## Fire Marshal Division

**RE: Ed's Restaurant Expansion**  
**53 E. Depot St.**  
**Angier, NC 27501**

**Application Number – FMFW1904-0005**

NAME	DATE	IF ANY CONDITIONS NECESSATE SUBSTANTIAL CHANGE FROM APPROVED PLAN, AS INSTALLED PLANS SHALL BE SUBMITTED TO THE AUTHORITY HAVING JURISDICTION	REV
SEM	4/12/2019	DWG. NO.	
136596			<b>A</b>

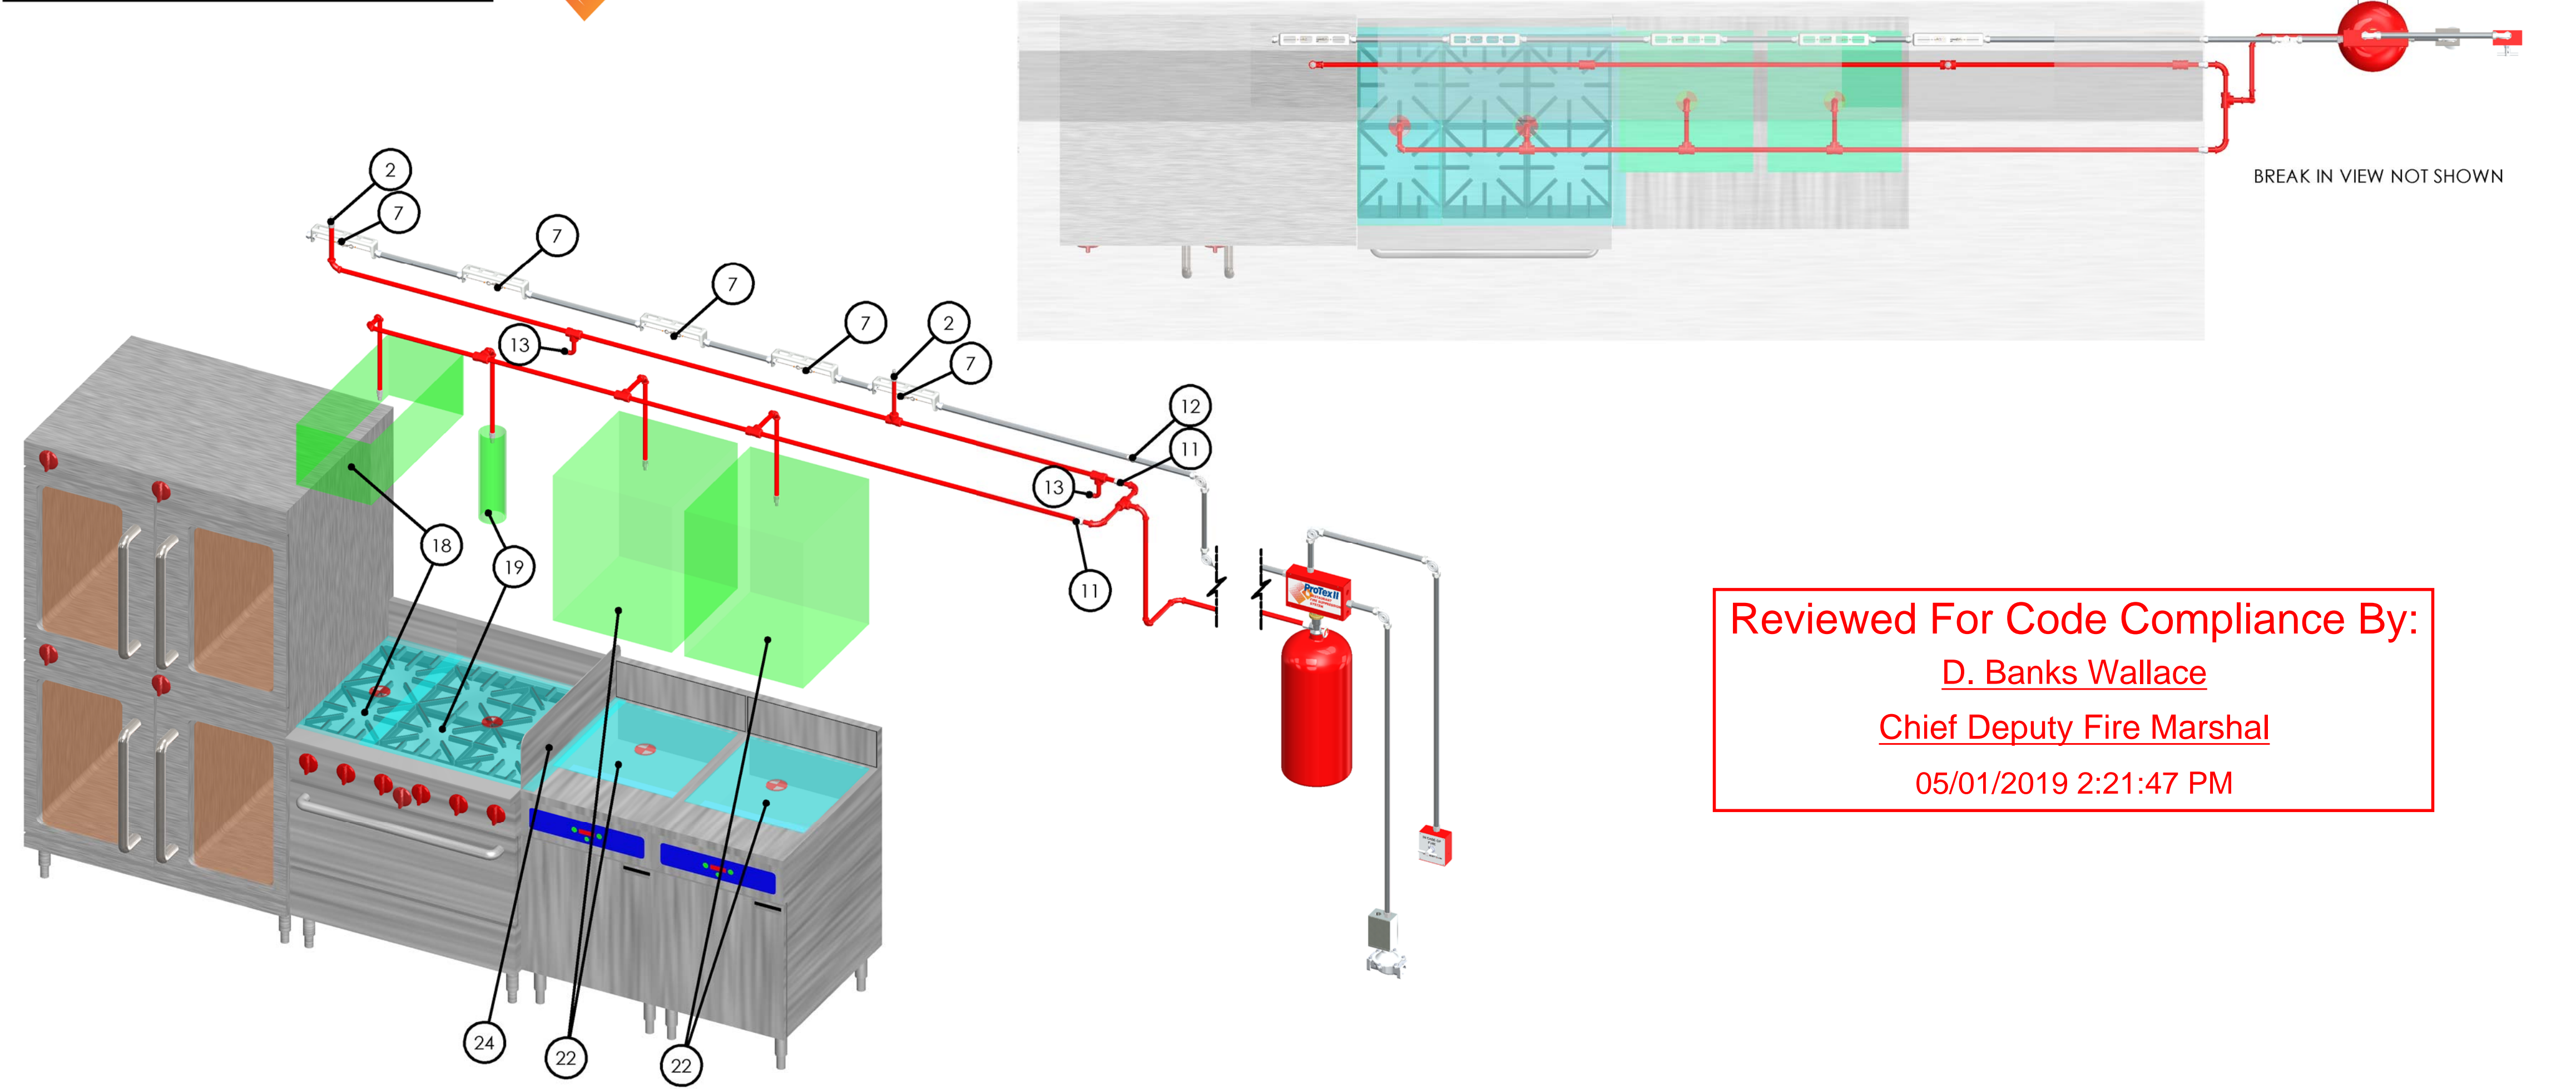
- **Commercial cooking equipment.**
  - A multi-purpose ABC type extinguisher (minimum 2A-10BC) shall be provided and mounted within 5ft. of the finished floor with a maximum travel distance of 75 ft.
  - Portable fire extinguishers shall be provided within a 30-foot (9144 mm) travel distance of commercial-type cooking equipment. Cooking equipment involving vegetable or animal oils and fats shall be protected by a Class K rated portable extinguisher.

- **Manual system operation**
  - A manual actuation device shall be located at or near a means of egress from the cooking area, a minimum of 10 feet (3048 mm) and a maximum

of 20 feet (6096 mm) from the kitchen exhaust system. The manual actuation device shall be located a minimum of 4.5 feet (1372 mm) and a

maximum of 5 feet (1524 mm) above the floor. The manual actuation shall require a maximum force of 40 pounds (178 N) and a maximum movement of 14 inches (356 mm) to actuate the fire suppression system.

- **System Interconnection**
  - The actuation of the fire suppression system shall automatically shut down the fuel or electrical power supply to the cooking equipment. The fuel and electrical supply reset shall be manual.

- **904.3.5 Monitoring**
  - Where a building fire alarm system is installed, automatic fire-extinguishing systems shall be monitored by the building fire alarm system in accordance with NFPA 72.
